**Consultation Response from KC,
Highways Development Management**

2026/90710 11a, Roydhouse, Drinker Lane, Shelley, Huddersfield, HD8 8LR

Erection of extension and alterations to existing garage to form dwelling with associated external works

Date Responded: 11 May 2026

SITE PLAN
AS EXISTING &
AS PROPOSED

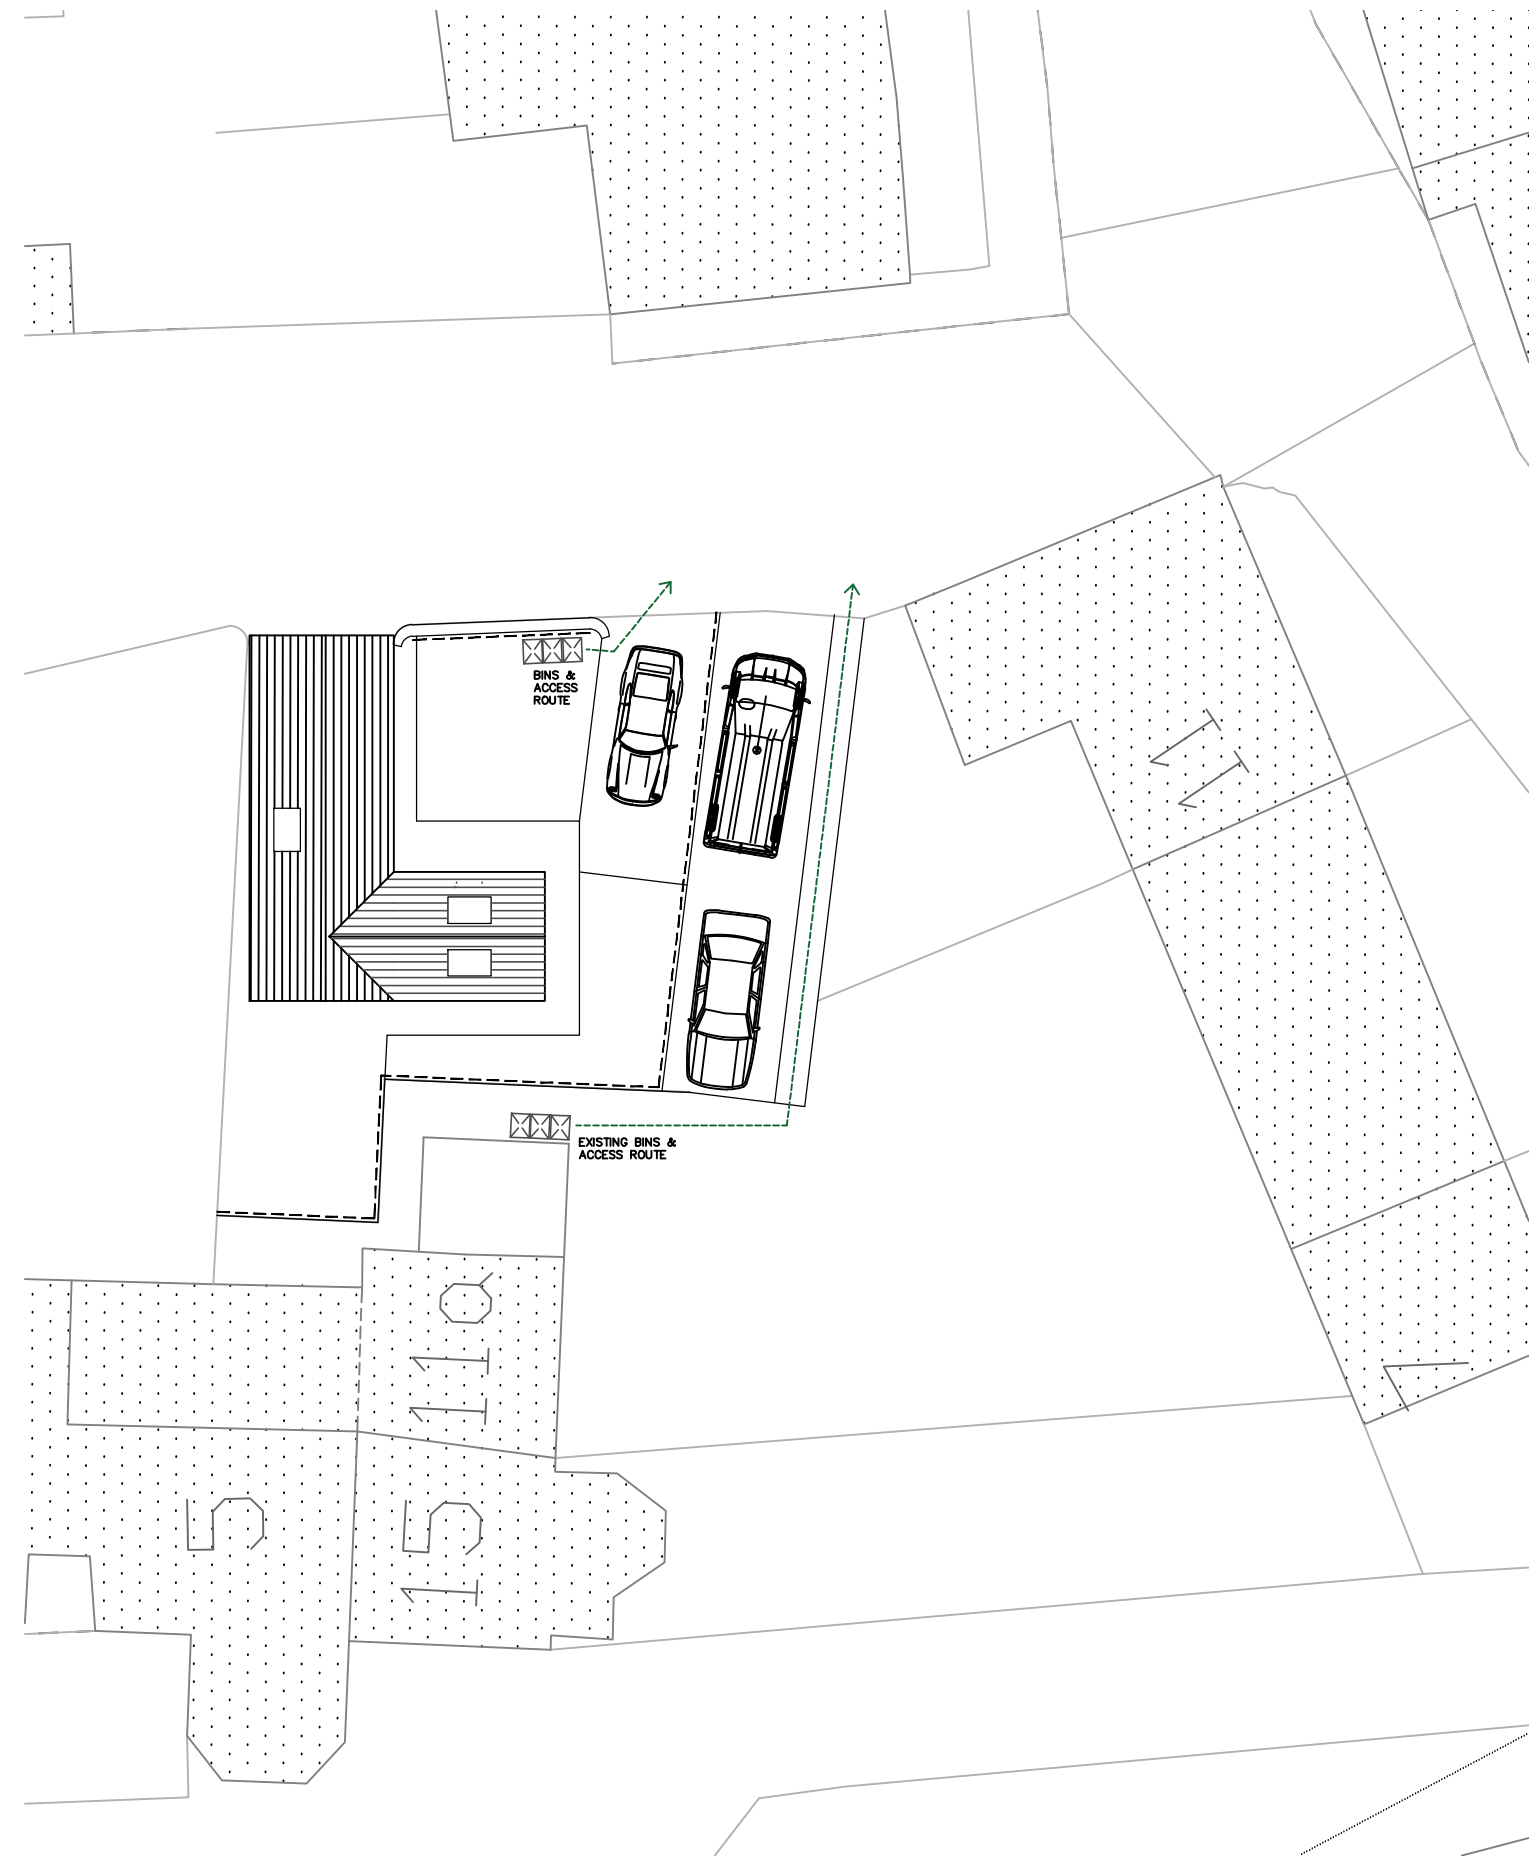
Residents of the proposed one bedroomed dwelling with driveway parking and bin storage are likely to be expected to be dependent upon motorised vehicles for travel purposes due to the rural location.

To improve the sustainable travel offer, cycle parking is recommended in an enclosed and secure facility to accommodate at least one bicycle in line with the Kirklees Highway Design Guide SPD. Additionally, for an electric vehicle charging point to be installed.

The existing access from the shared surfaced unadopted lane over which Public Right of Way, footpath KIR/183/10 passes is to be widened on altering the boundary treatment and removing planting and a tree. That serving the garage is to be closed off. Both the existing and proposed access are of sufficient width to cater for shared used by pedestrians and vehicles.

The proposal illustrates conversion and extension of the existing garage with the creation of a new driveway parking adjacent the existing facility.

The existing driveway is retained and is sufficient to serve two vehicles. The intended driveway is sized adequately to serve one car.

The amount of parking would be enough to meet advice in the KHDG SPD of two spaces for two / three-bedroom dwellings and one space for a one-bedroom unit and in line with Policy LP22.

There is adequate space for bin storage for both the existing and proposed unit for collection as undertaken, currently.

The proposal is unlikely to give rise to significant public or road safety issues with immaterial impact on network functionality including to the PROW to meet policy LP21.
